**KIRKLEES METROPOLITAN COUNCIL
INVESTMENT & REGENERATION SERVICE**

Reference No:	2024/60/92768/W
Site Address:	land rear of, 23, Dalton Fold Road, Dalton, Huddersfield, HD5 9NL
Description:	Outline application for one detached single storey annex dwelling at, land to rear of 23 Dalton Fold Road, Dalton, Huddersfield, HD5 9NL
Recommending Officer:	Lucy Taylor

DECISION – CONDITIONAL OUTLINE PERMISSION

Officer Report.

| scale | date | sheet size | dwg. no. |
|-------|---------|------------|------------|
| 1:500 | 05/2024 | A3 | 23/941/04a |

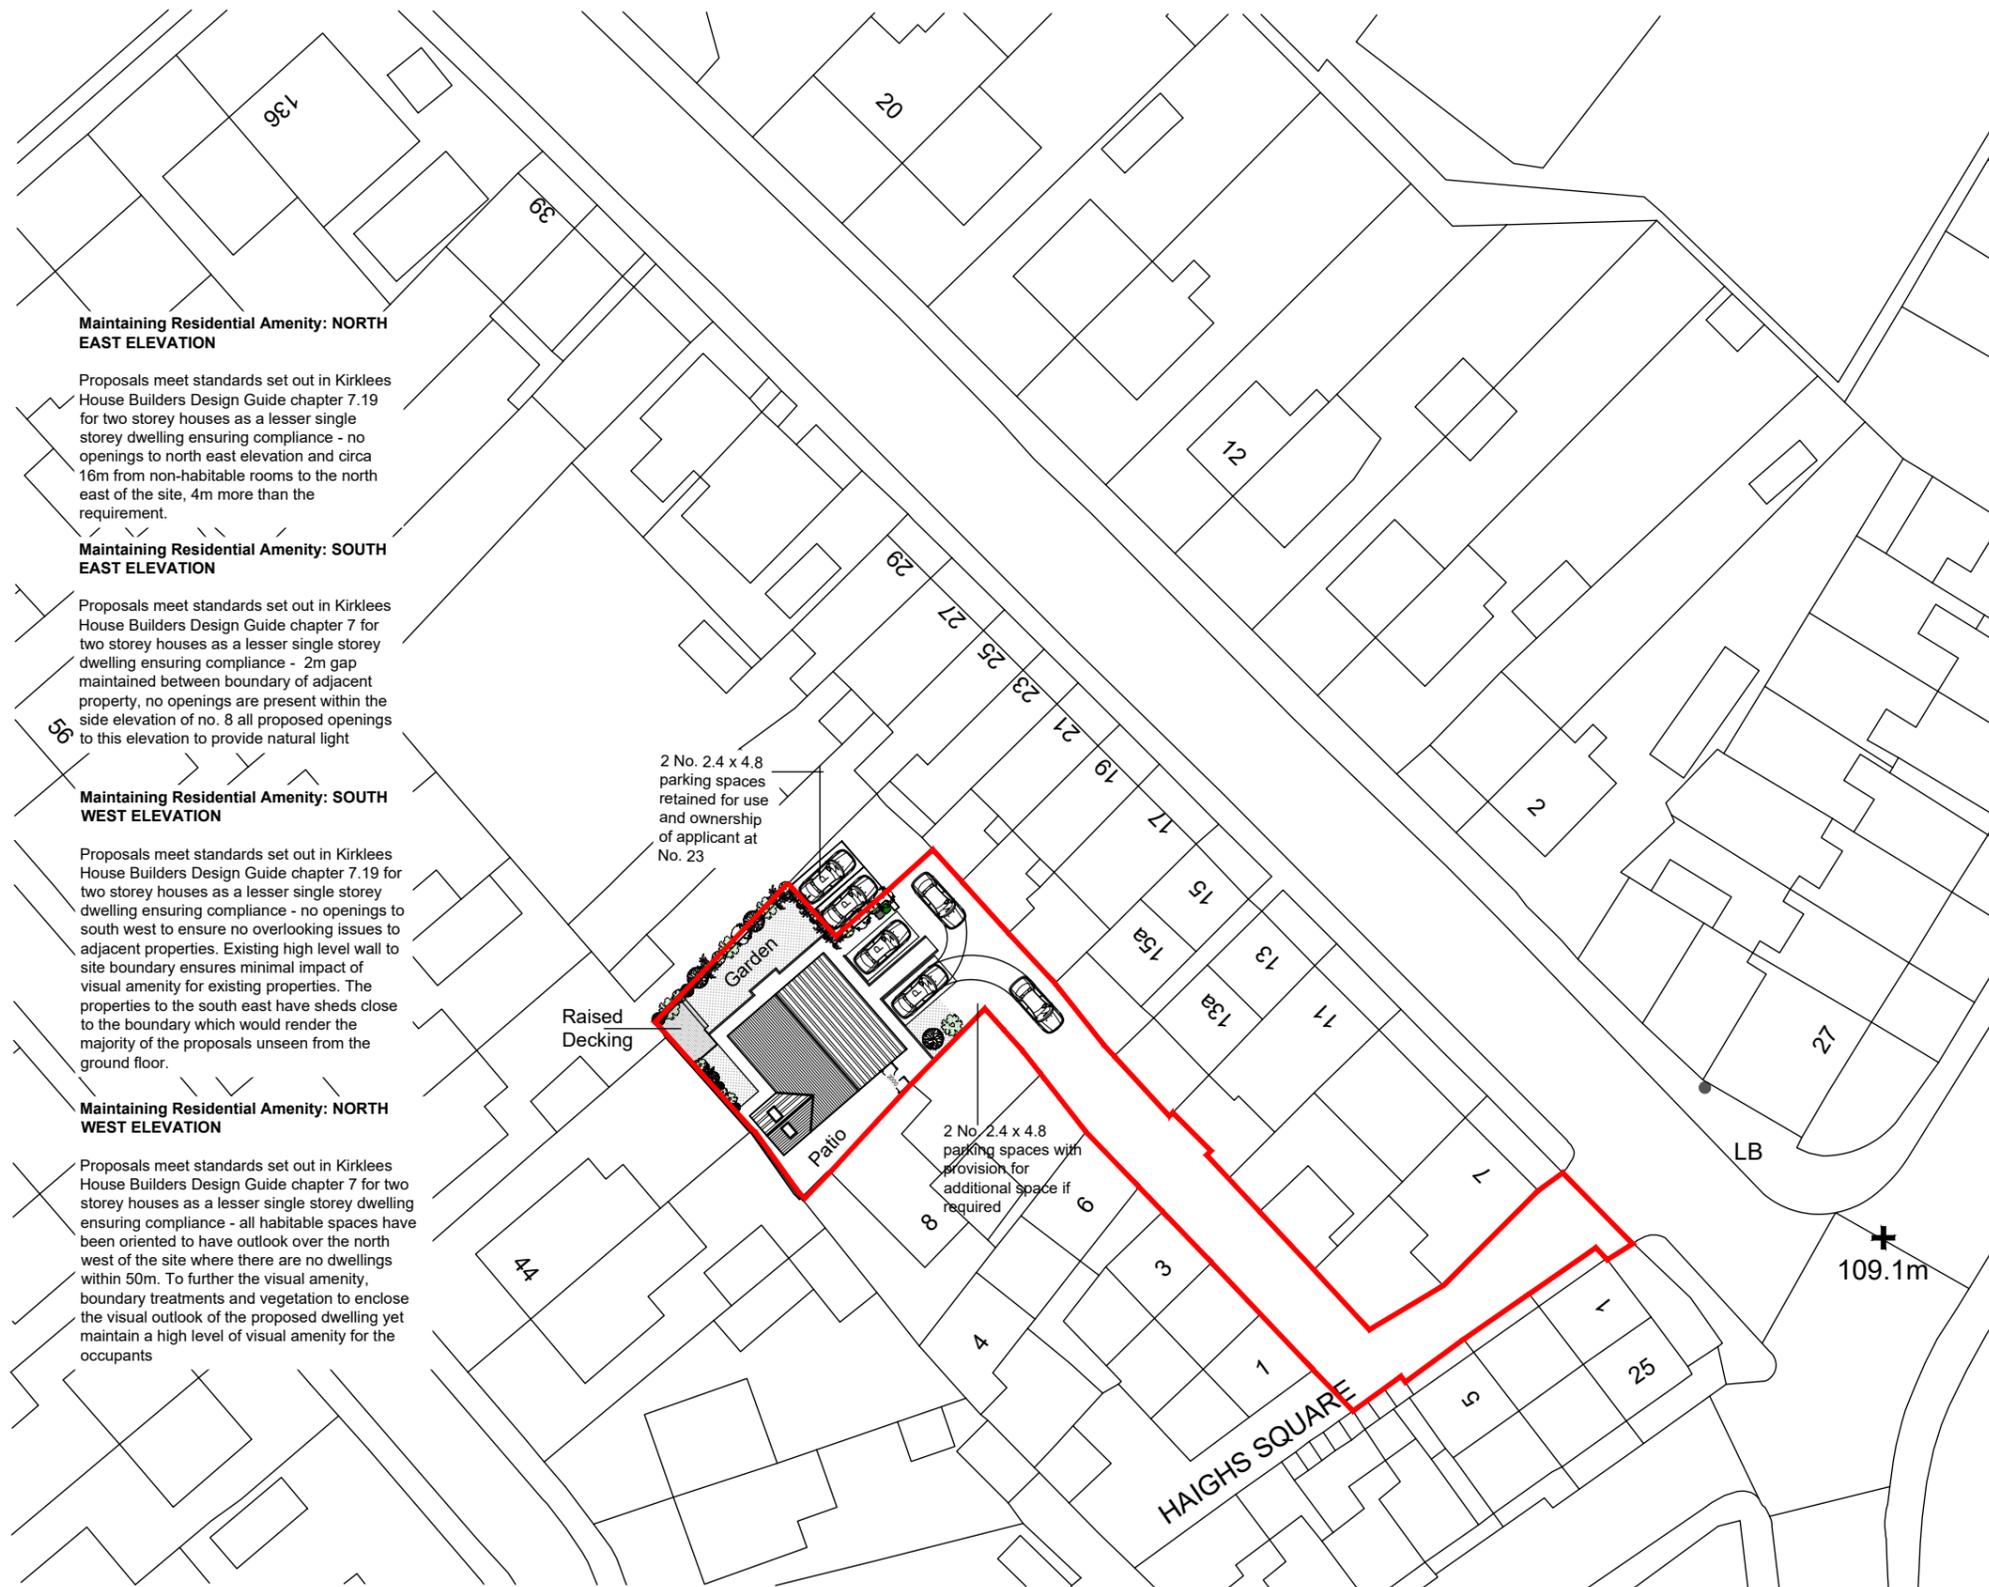
In accordance with Principle 5 of the Housebuilders Design Guide SPD, it is recommended that the proposed building be aligned and set-back to form a coherent building line. The proposed ancillary dwelling should therefore align with the siting of the residential dwellings to the south east, including No. 8 Haighs Square, which immediately neighbours the site to this side. It is noted that the indicative proposed plans show the siting of the ancillary dwelling approximately 1.5 metres forward of the building line of this neighbouring property.

Furthermore, Principle 5 also sets out that buildings should front on to the street, with well-designed frontages and prominent front doors. Given the siting of the proposed ancillary dwelling, it is recommended that the elevation facing the unadopted access road host such fenestration detailing. Officers

note that on the submitted indicative plans, this elevation hosts an access door.

- approximately 1.9 metres from the shared boundary with No. 8 Haighs Square.
- a minimum separation distance of approximately 0.5 metres from the rear boundary shared with No.'s 42 and 44 Derwent Drive.
- approximately 10 metres from the boundary with the dwellings across the unadopted access road.

With regards to privacy, it is also noted that the indicative plans show an area of raised decking. Privacy should be a consideration for this element of the proposal, with any necessary privacy screens or forms of boundary treatment included and clearly indicated on plan at reserved matters stage. The raised decking is shown to be set against the shared boundaries with No.'s 44 and 46 Derwent Drive.

The indicative plans show bedroom and bathroom windows to be installed in the side elevation of the ancillary dwelling adjacent to No. 8 Haighs Square. Officer's note the presence of one window in a side elevation of No. 8 Haighs Square on the elevation facing towards the development site. Based on this, officers would reiterate the separation distances between habitable and non-habitable room windows as set out within Principle 6 of the Housebuilders Design Guide SPD.

The indicative plans show an access door and glazing to serve the hallway in the elevation facing towards No.'s 17, 19 and 21 Dalton Fold Road. The separation distances between habitable and non-habitable room windows, as set out within Principle 6 of the Housebuilders Design Guide SPD are reiterated.

The indicative plans show that the rear elevation of the ancillary dwelling, adjacent to these neighbouring properties, would be blank with no glazing. This design would be recommended up on the submission of any further reserved matters application, given the separation distances between habitable and non-habitable room windows, as set out within Principle 6 of the Housebuilders Design Guide SPD.
